Application Ref:	3/2025/0315			 Ribble Valley Borough Council <small>www.ribbonvalley.gov.uk</small>
Date Inspected:	N/A	Site Notice	11/06/2025	
Officer:	MC			
DELEGATED ITEM FILE REPORT:				APPROVAL

Development Description:	Listed Building Consent for reconfiguration of the art department entrance and reconfiguration of the CCF and IT classrooms to create Textiles and Design Technology teaching spaces.
Site Address/Location:	Stonyhurst College Avenue Road Hurst Green Clitheroe BB7 9PZ

Drawing
Art Lobby Junction and Opening Details

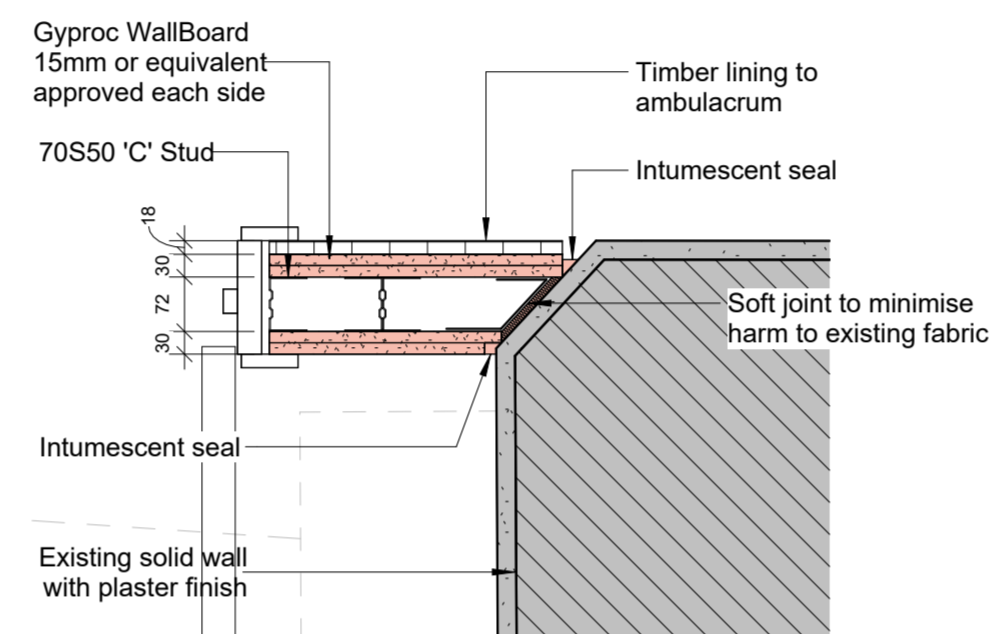
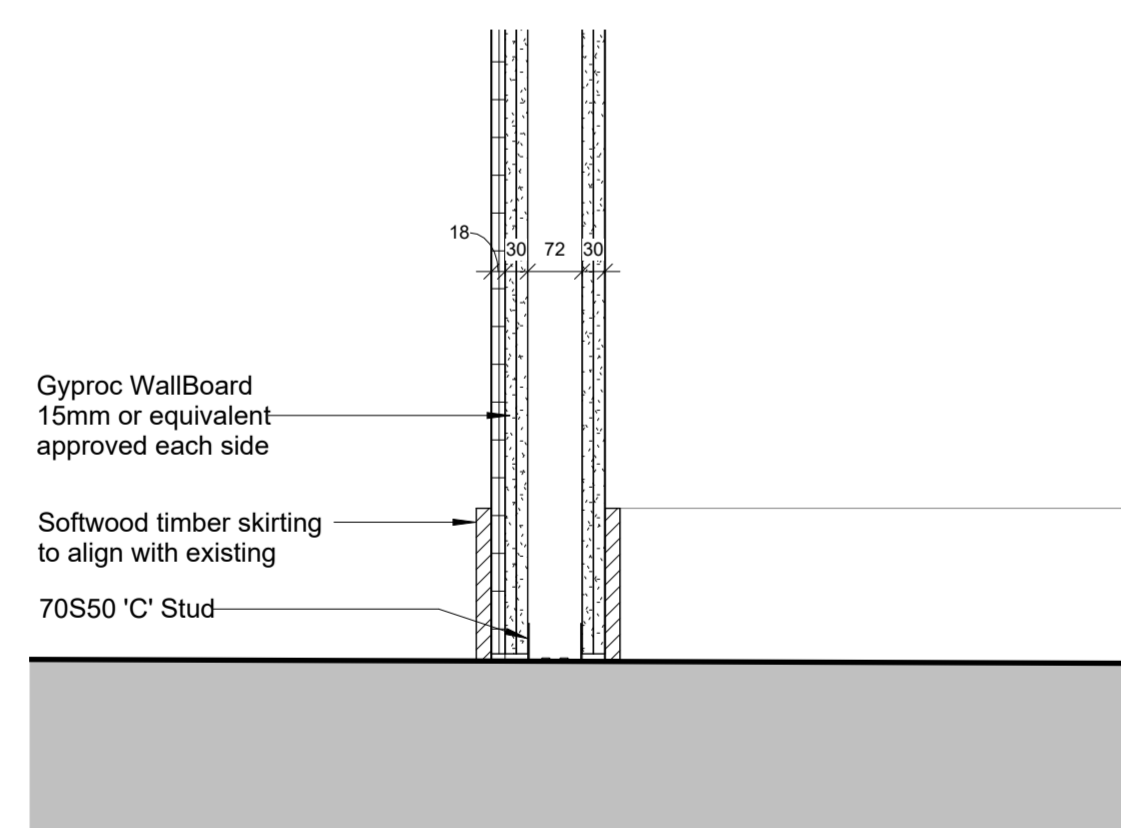
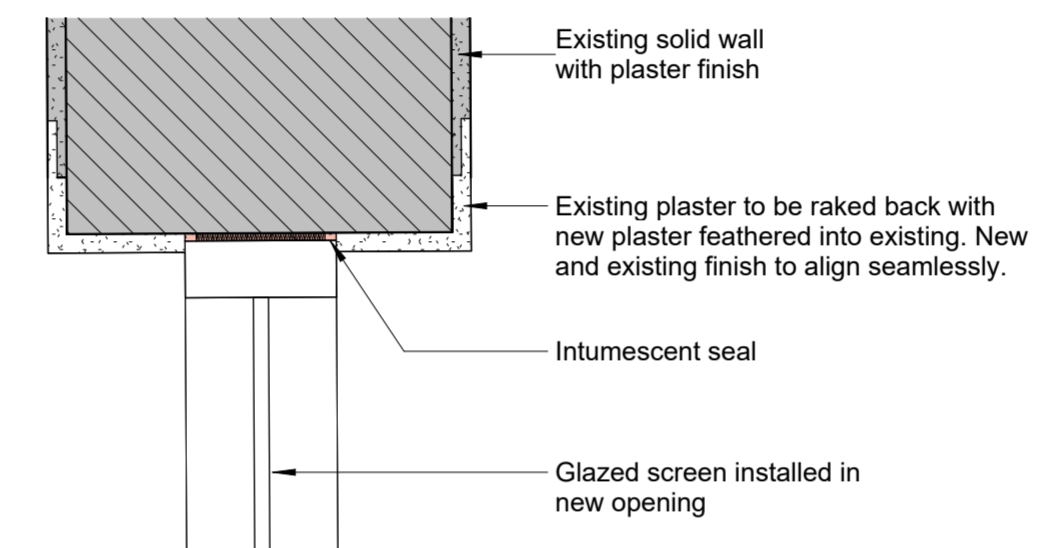
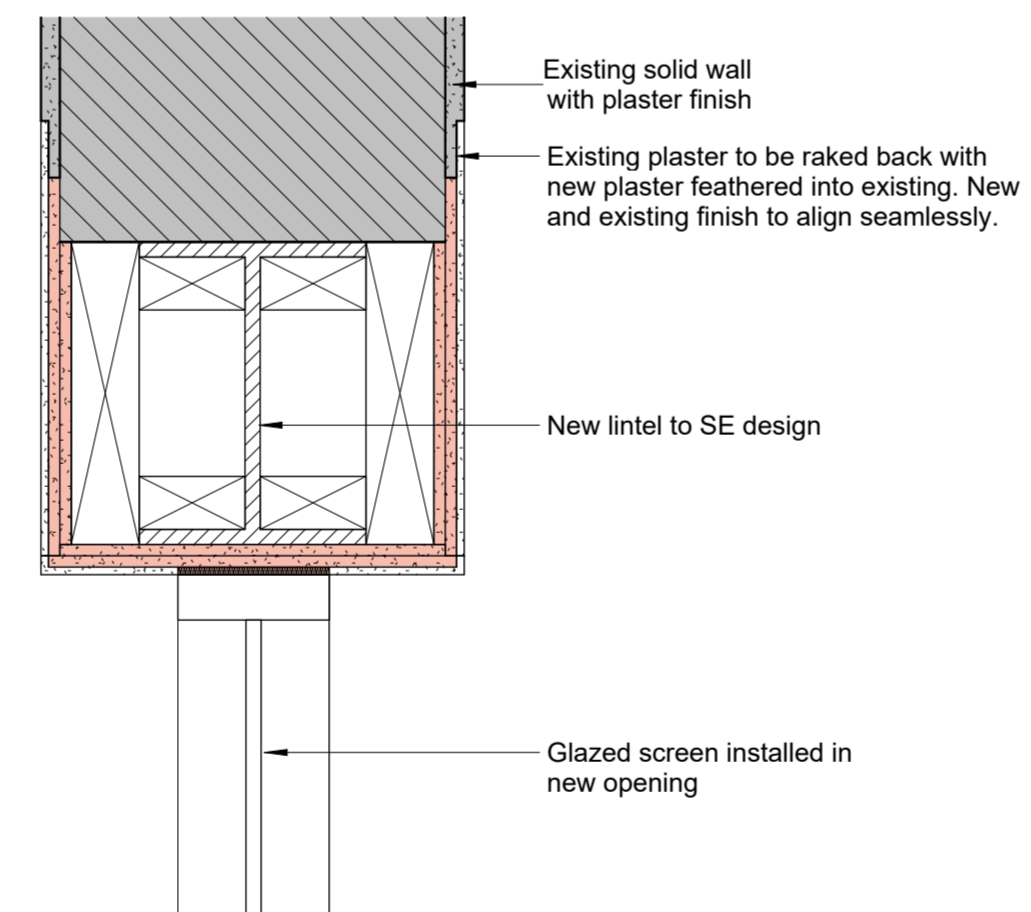
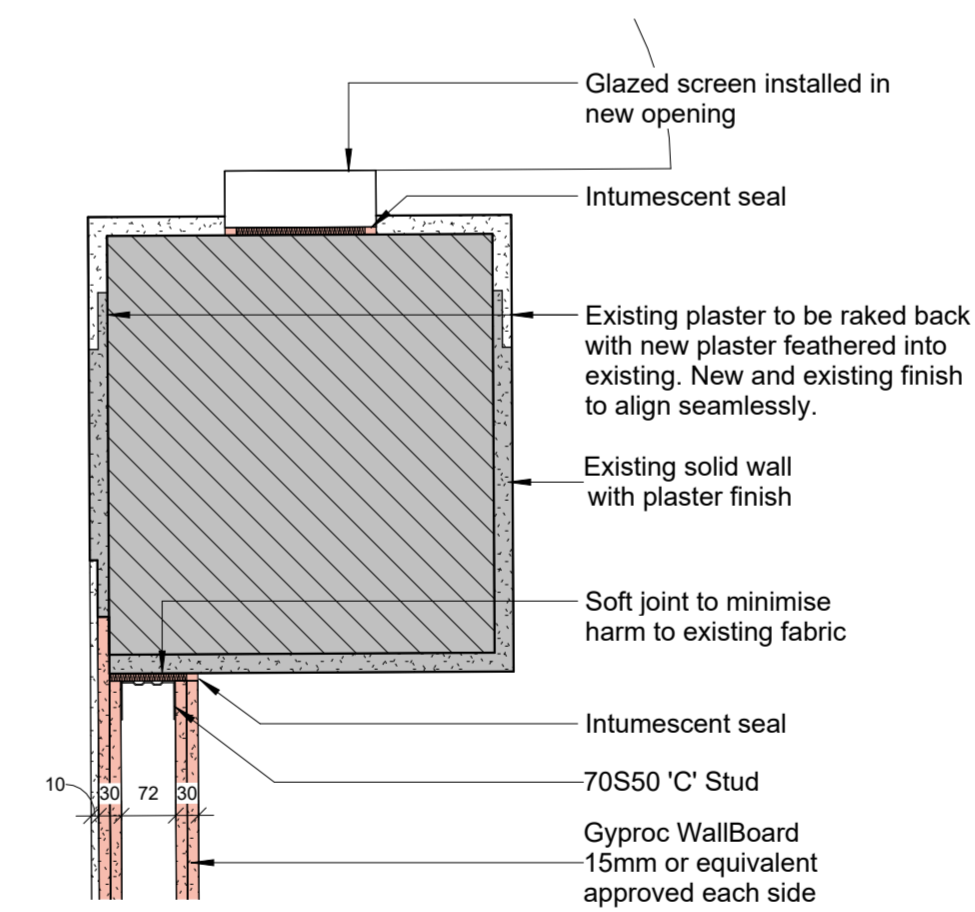
They note that the proposed works would result in the creation of a wider, more centrally placed entrance into the art department, which is historically significant to the college. Currently there is no division between the art dept and ambulatory, and the appreciation of the ambulatory is somewhat hindered by the presence of a large access ramp and views into the art dept and the modern, more functional cupboards and accretions.

They consider that the creation of the new entrance would result in some minor loss of walling fabric, which given the scale of loss is considered to be on the very low end of less than substantial harm.

Demo Floor Plans - Art

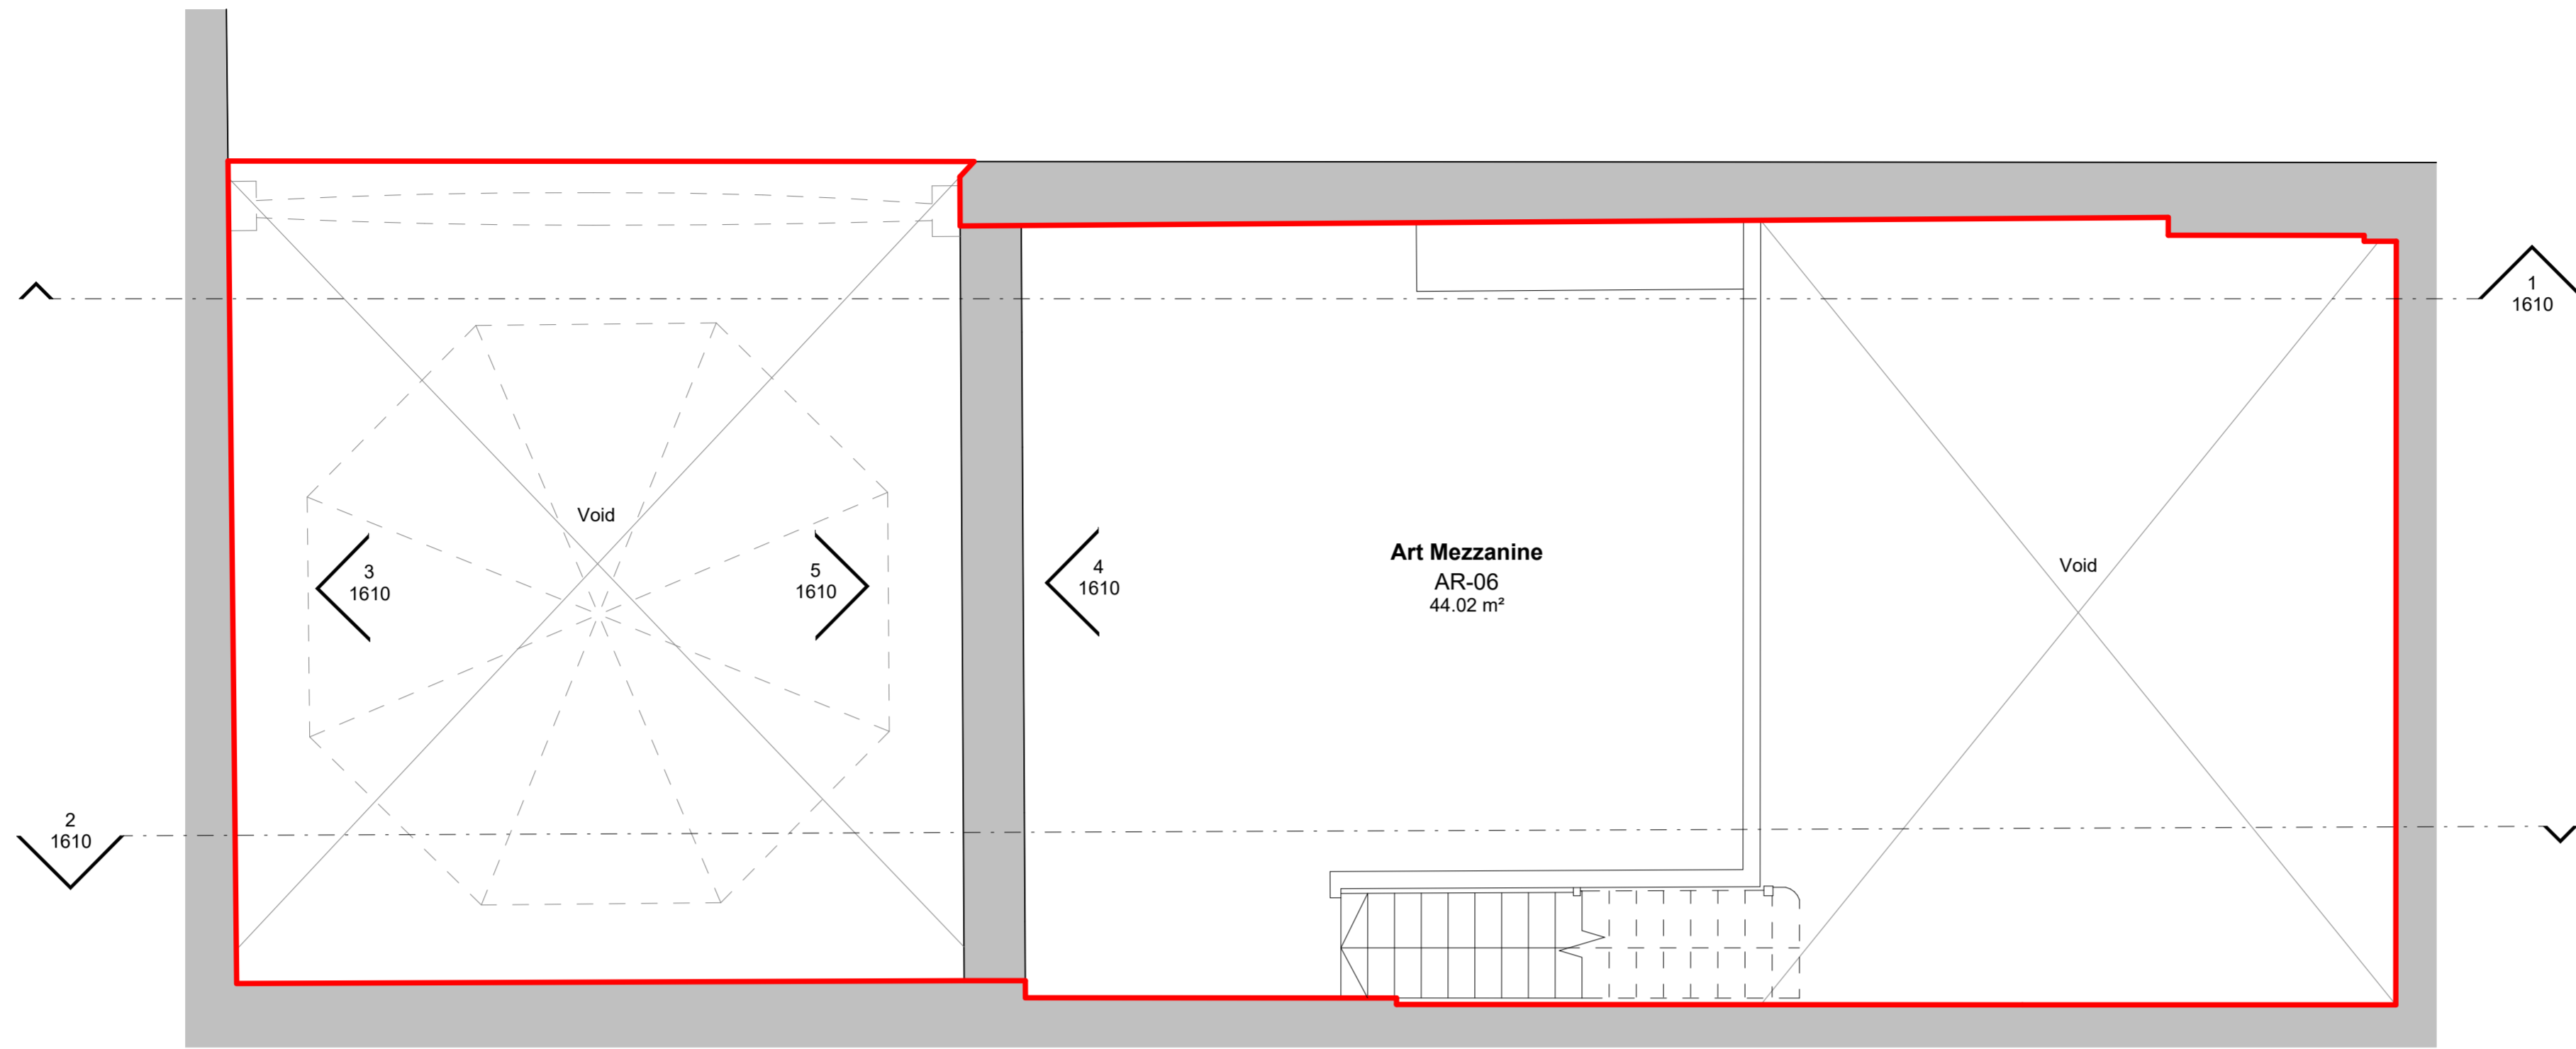
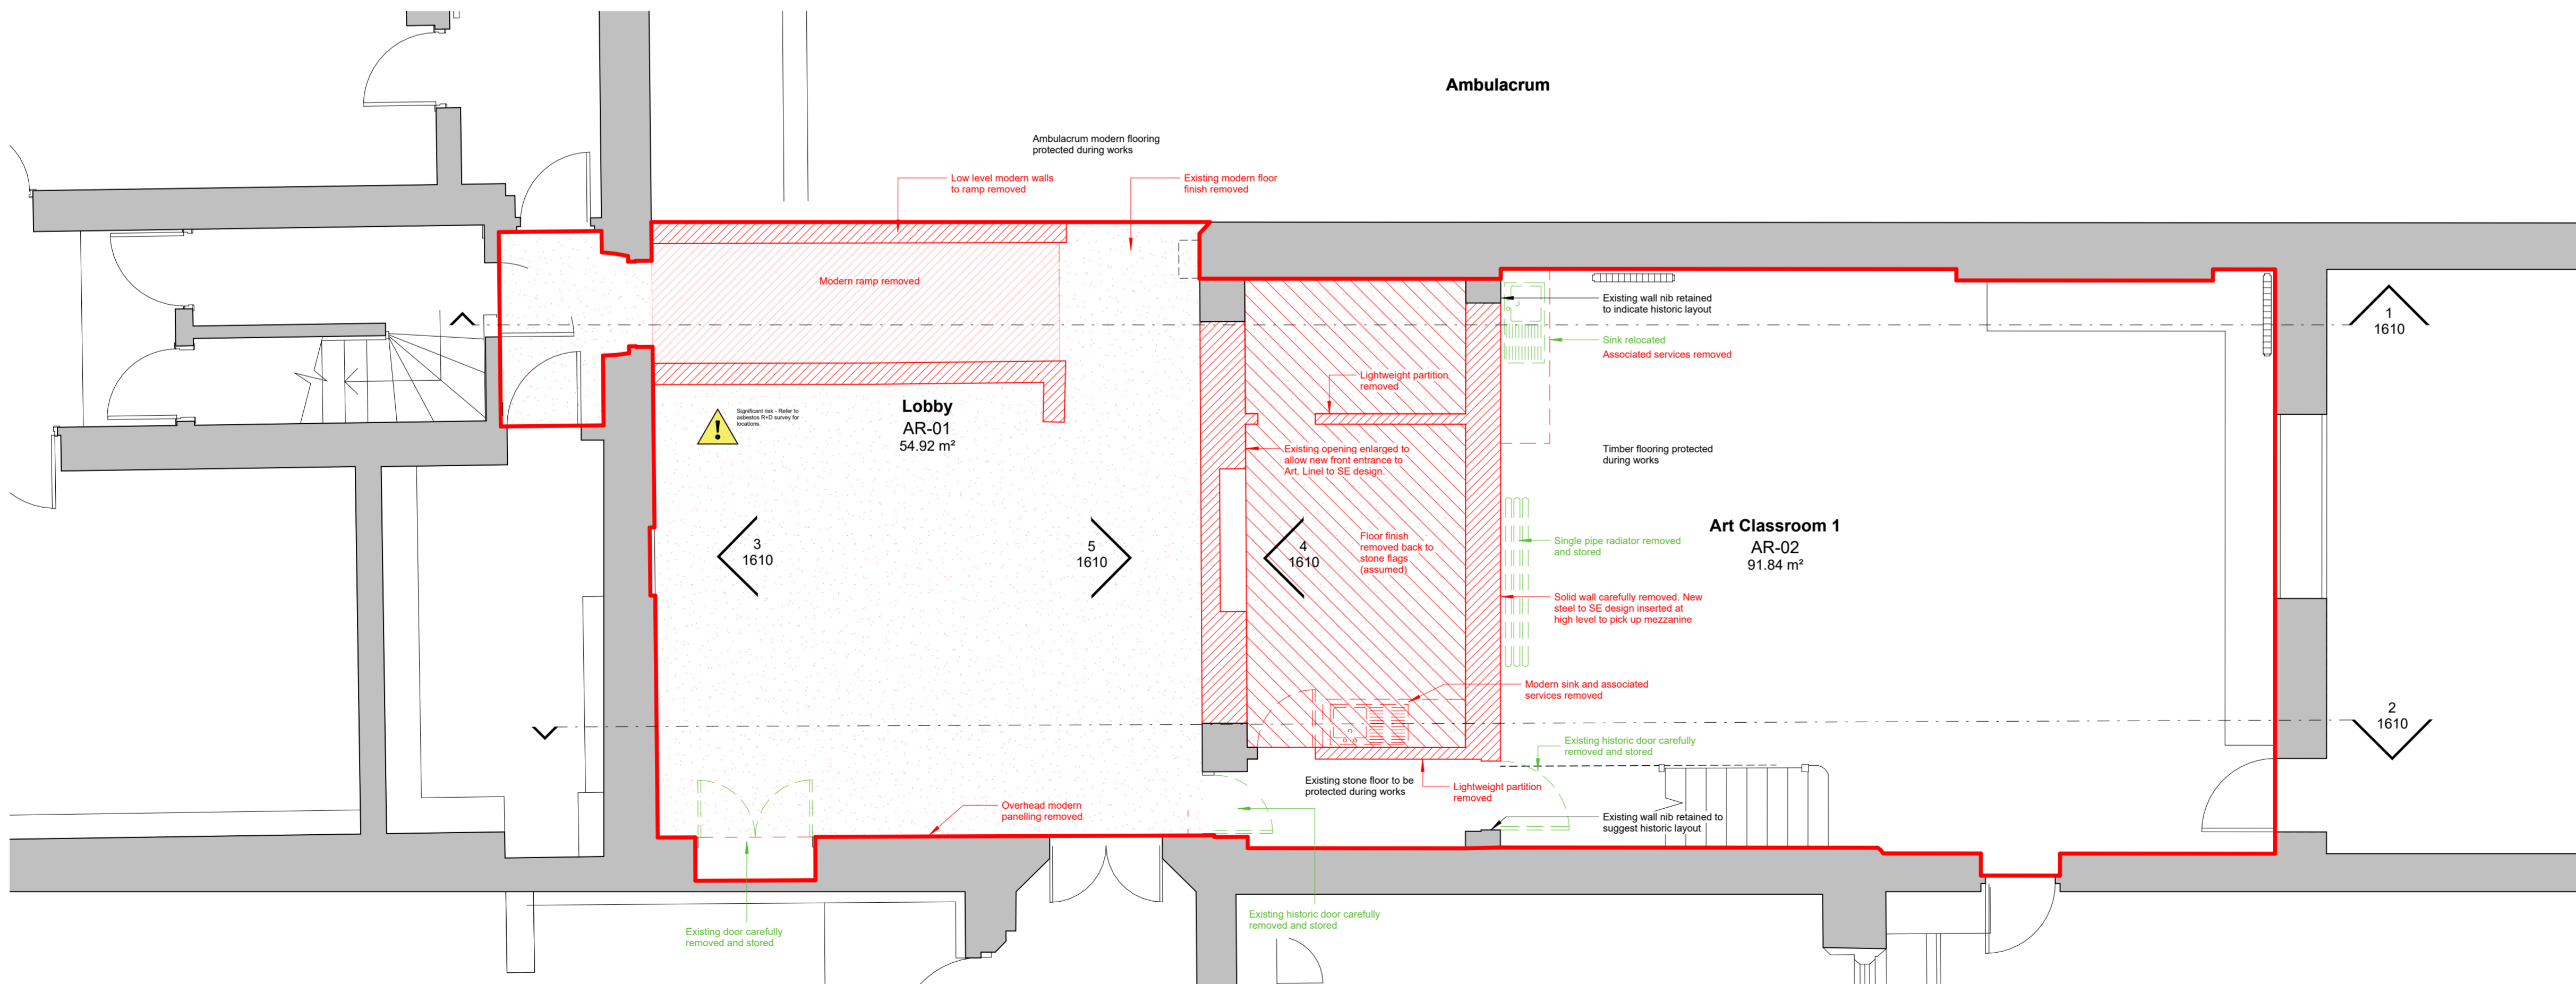
The proposed development includes works to the existing art department. The works include the demolition of some limited masonry fabric for creation of a wider, more centrally placed entrance into the art department, which is historically significant to the college. In addition, the proposal includes the removal of the modern partition of the storage room and the creation of a new entrance to the lobby and new glazed screening between the Lobby and Art Classroom 1. A C19 door would be removed in placed in storage and an existing unsympathetic C20 storage room, C20 cupboards attached to the walls and a C20 ramp and low level modern walls would be removed in the lobby. removal of a C20 ramp

The proposal originally included new glazed openings to the mezzanine floor, however following consultation with the Heritage and Conservation Officer, these have now been omitted from the scheme.

They note that the existing narrow entrance door, which is a modern door in a modern opening, leads into a passage with stone covered flooring leading to the art room (the first of the former science labs), and to the north is a small room currently used for storage, that has been created in the late C20. This is considered to be a negative space and the removal of the modern partition of the storage room is considered positive.

A C19 door is proposed to be removed and placed in storage. This would be of very low significance as it has been altered/damaged through the insertion of a staircase in the late C20. The Heritage and Conservation Officer notes that it would be stored on site and any harm would be negligible.

The Heritage and Conservation Officer considers there to be heritage benefits to the scheme which include the removal of the unsympathetic C20 storage room, C20 cupboards attached to the walls, removal of a C20 ramp which takes up considerable space below the lantern and re-placing in the west wall in a more discrete location, which will allow the historic ambulatory space and former labs to be appreciated more fully. They also consider that the proposed works to the CDT block will have no bearing on the significance of the listed building.
